Our Ref: 20/01091/HOU
Your Ref:

LOCATION: 1 Elmwood Road, Portsmouth, PO2 9QL, ,

PROPOSAL: Construction of rear extension and two storey side extension
(20/01091/HOU)

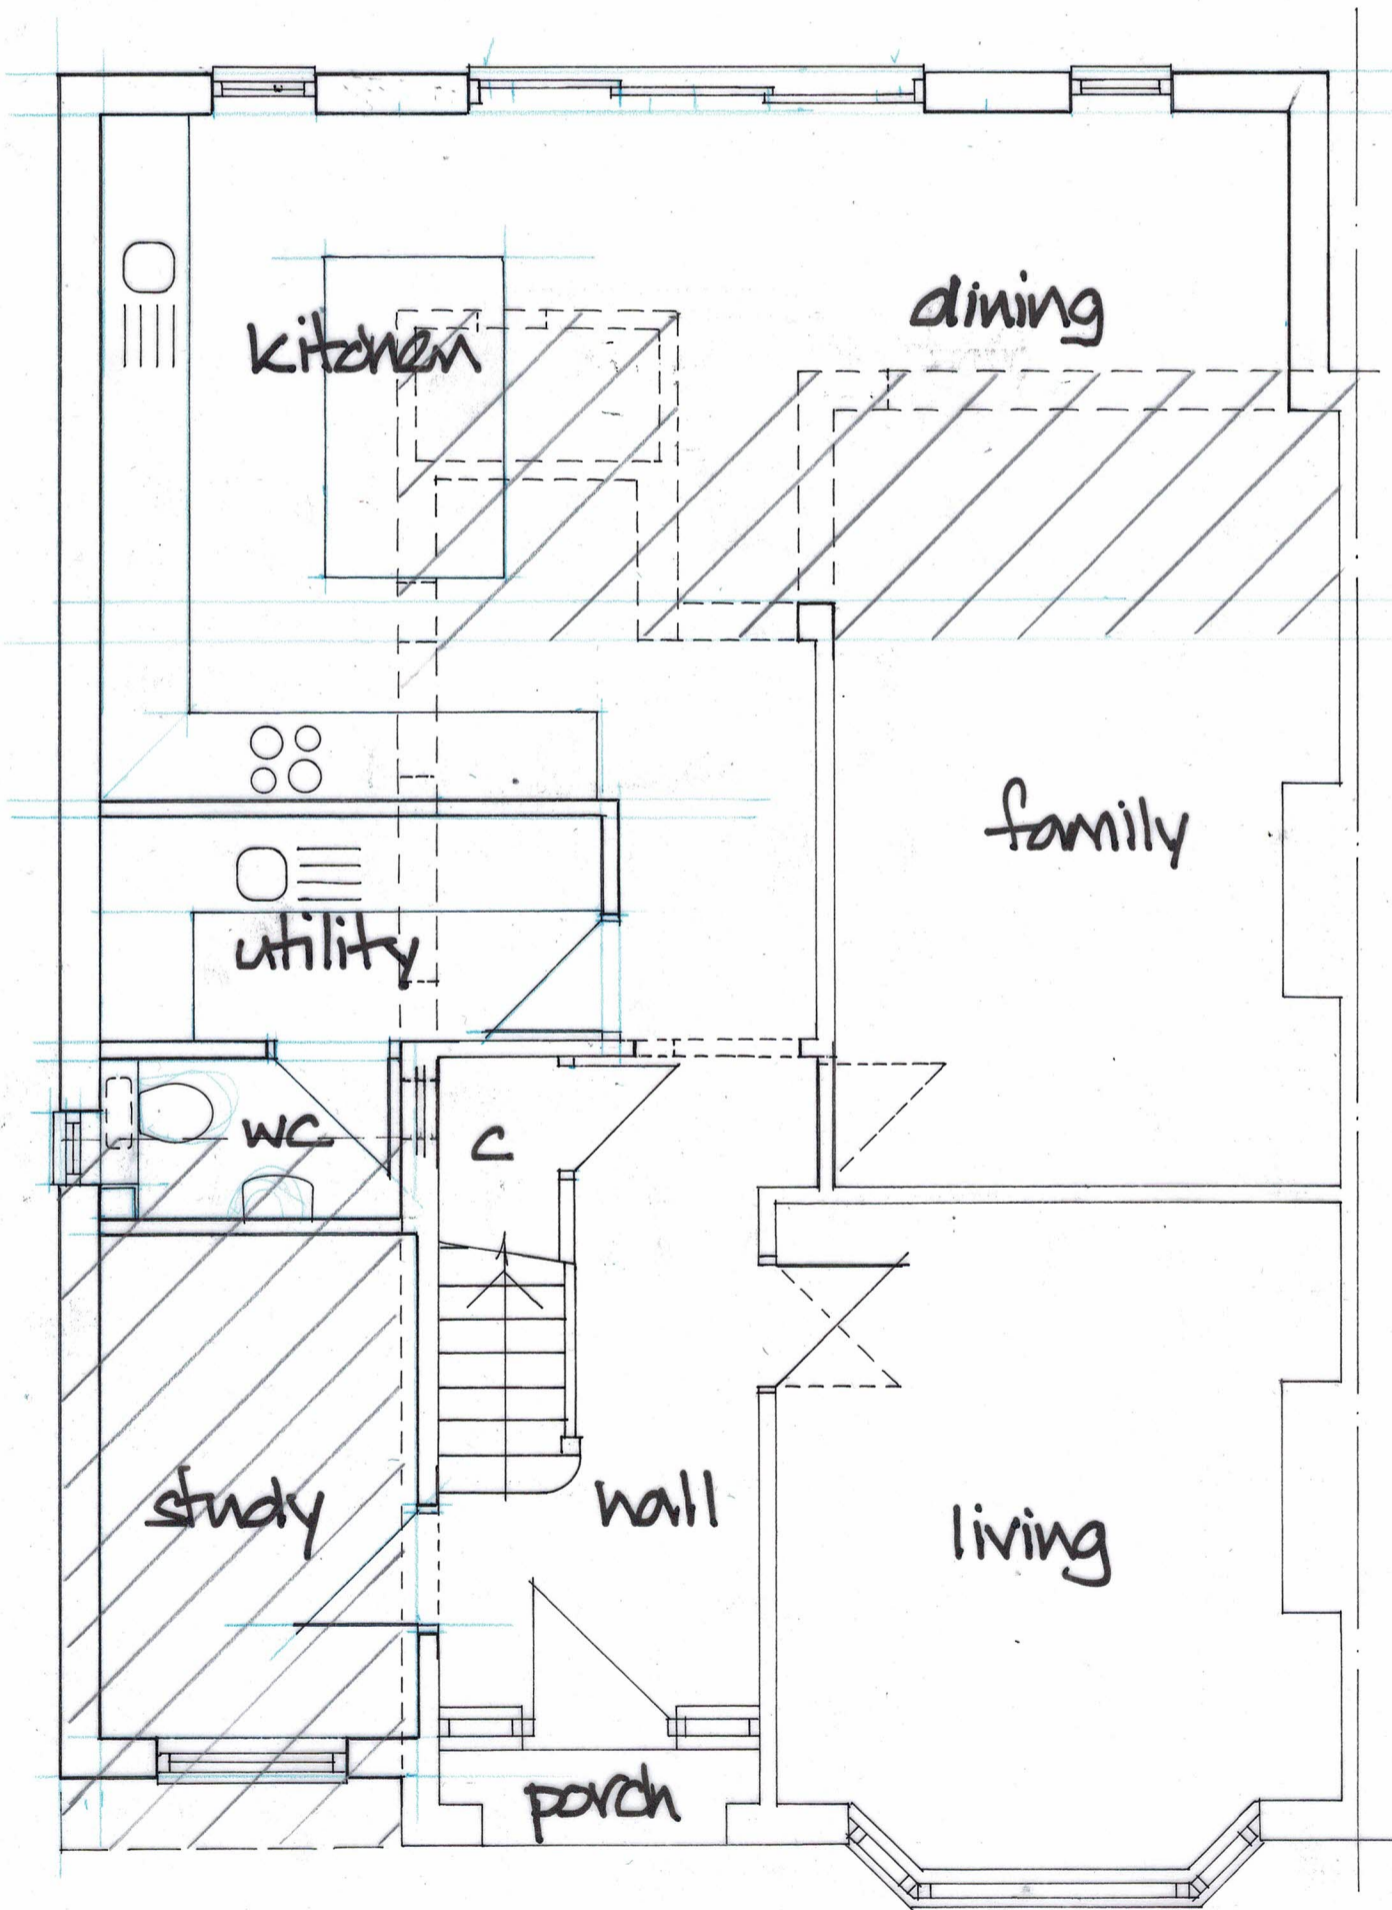
1) The proposed side elevation does not match the floor plan. Please amend accordingly
